Freedom Forever  
Planset Revision Letter

5/25/2023  
REV #1

JOHNNY F ALLEN  
214 TWIN OAK DR, ANGIER, NC 27501

**Revision Details:**  
LAYOUT CHANGE

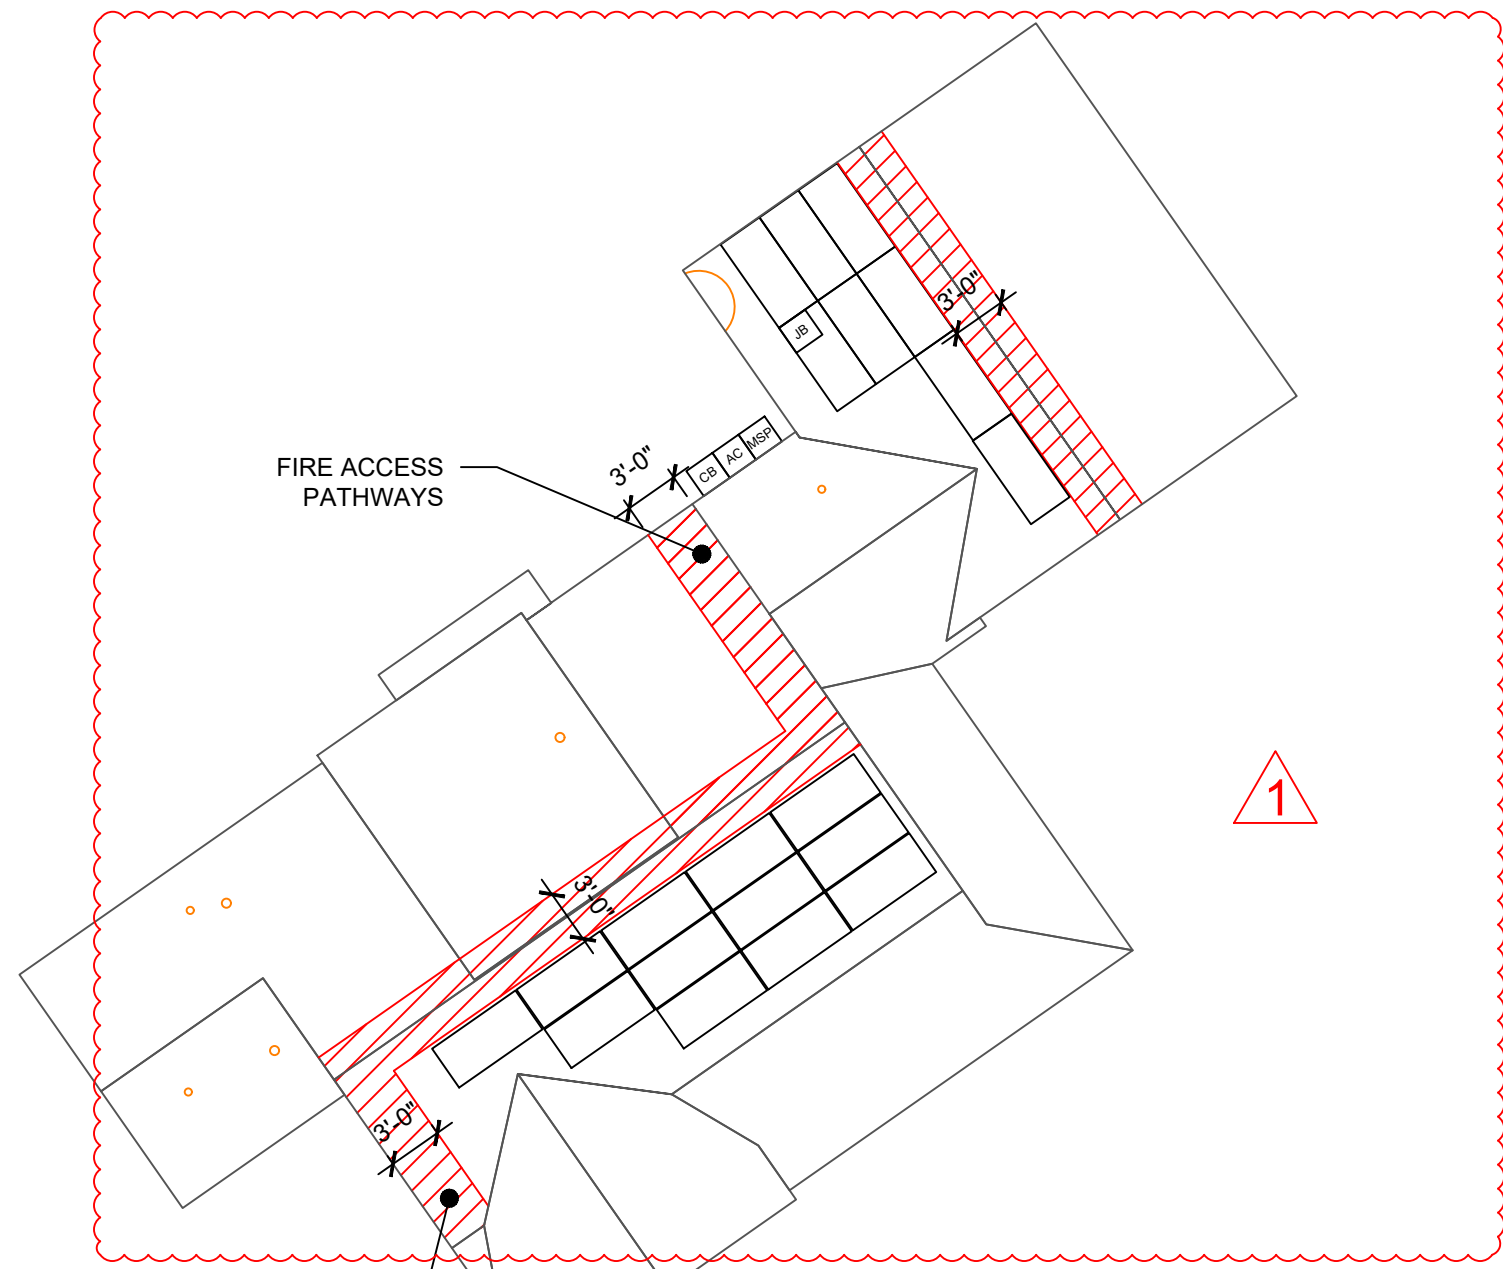
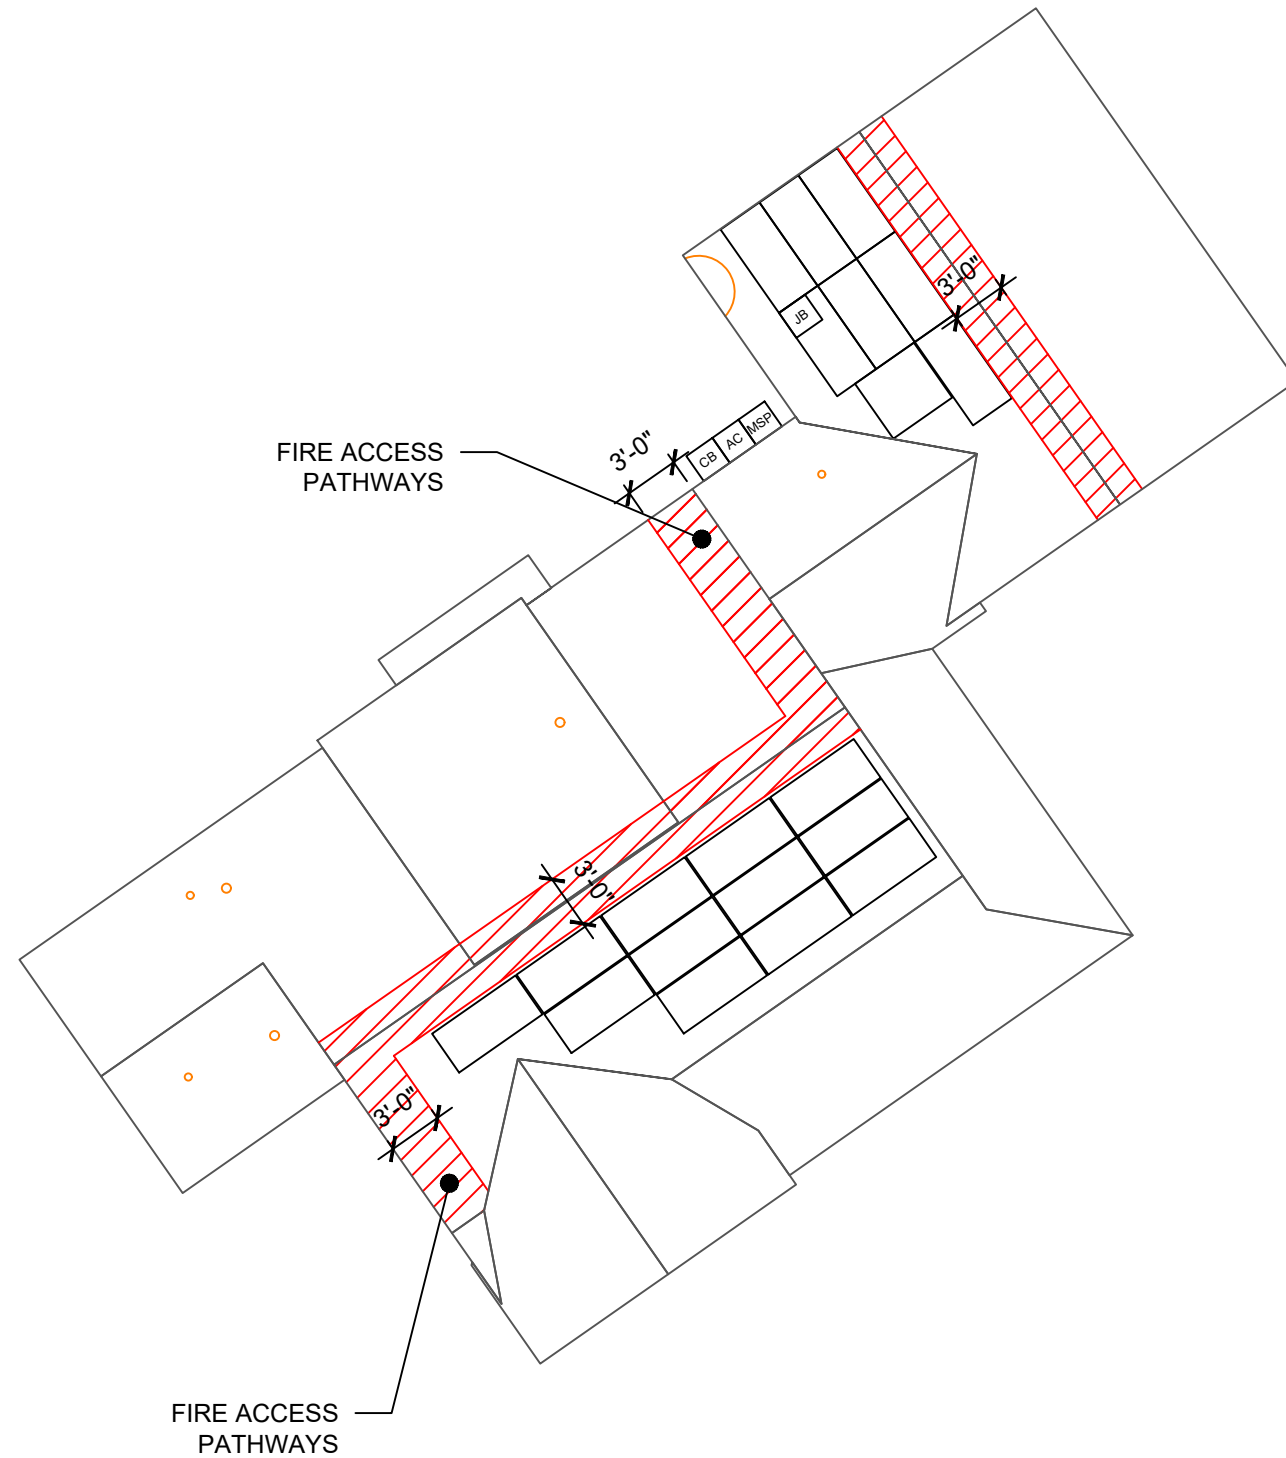
All corresponding changes are notated on the plans by revision clouds.
